Re: Major Project MP08_0244 Environmental Assessment (EA) for Construction of a Mixed Use Commercial, Retail and Residential Development at 23-37 Lindfield Avenue and 11 Havilah Avenue, Lindfield

I am writing to express **key objections** regarding the above EA.

1 JUNE 21 -9AM
1:500

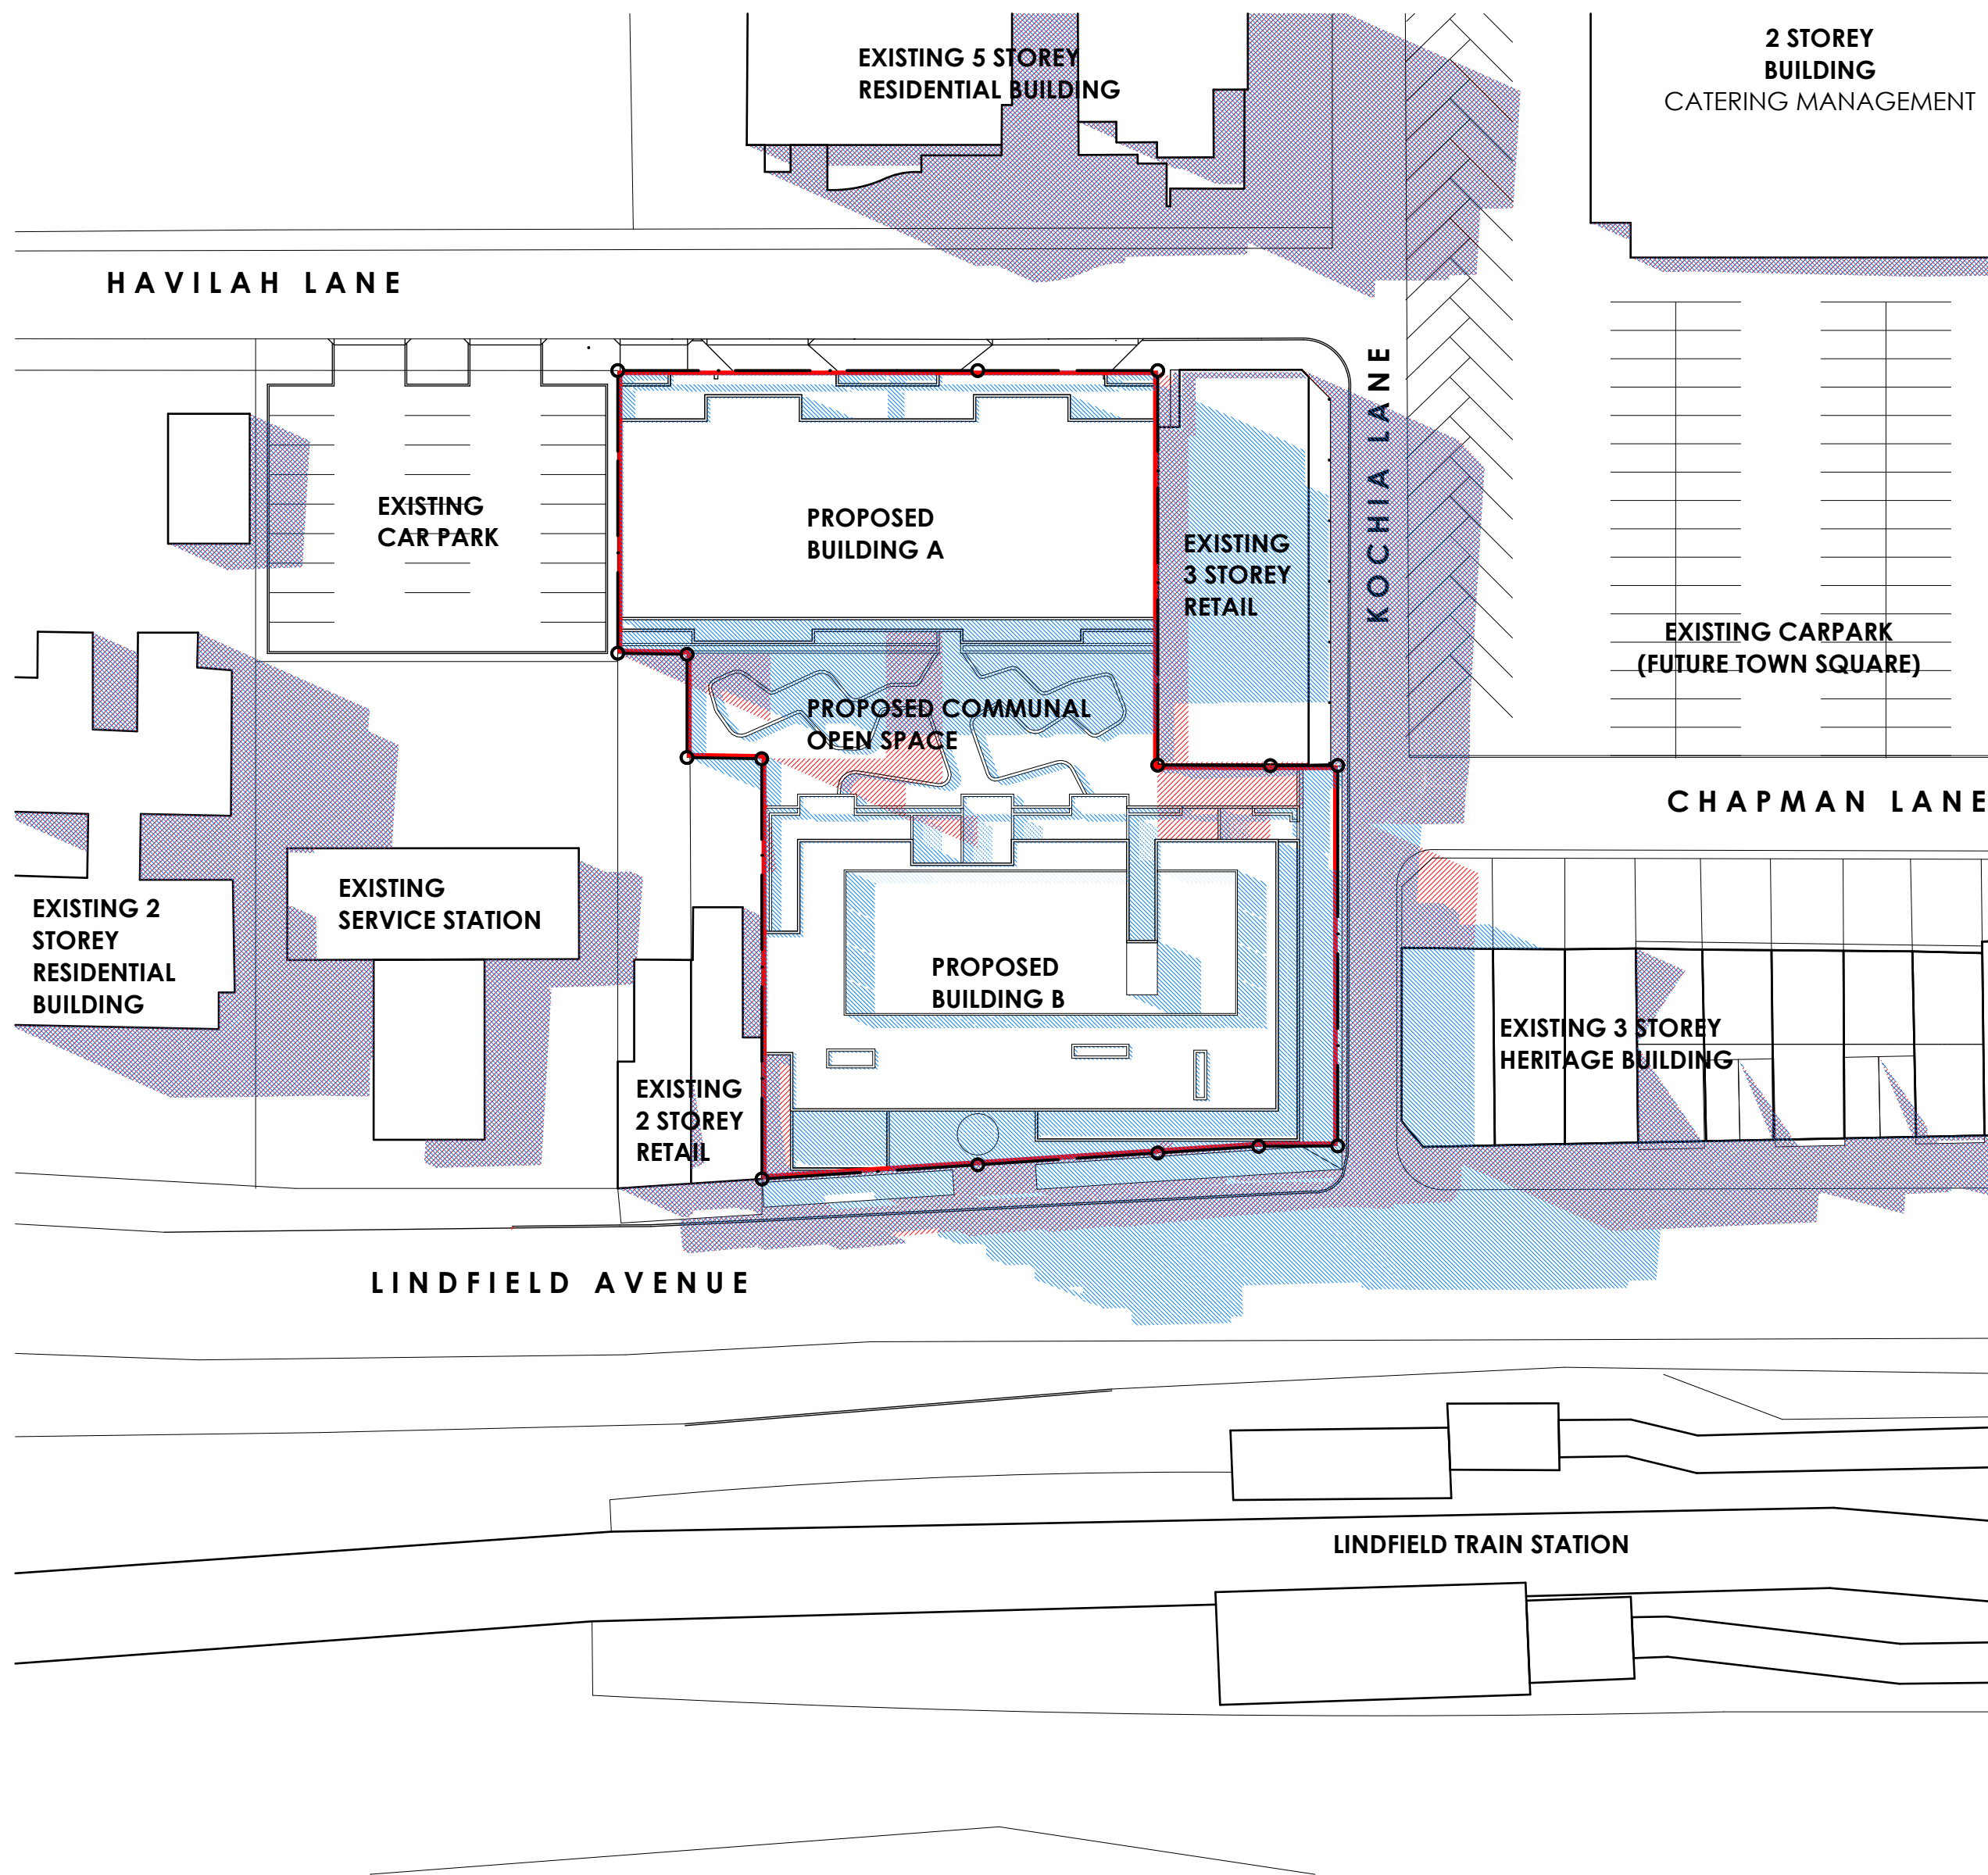
- The Lindfield Avenue building at 7 storeys will cast **significant shadow on the railway station (which is an open station)**, affecting a larger number of commuters as per the March, June and September Shadow Diagrams.

- **The development will cast significant shadows on future open space in the proposed town centre, causing loss of amenity to the broader community**, as per the June and September Shadow Diagrams.

b) Maintain development to a maximum of 5 storeys, in line with the broader Lindfield environment.
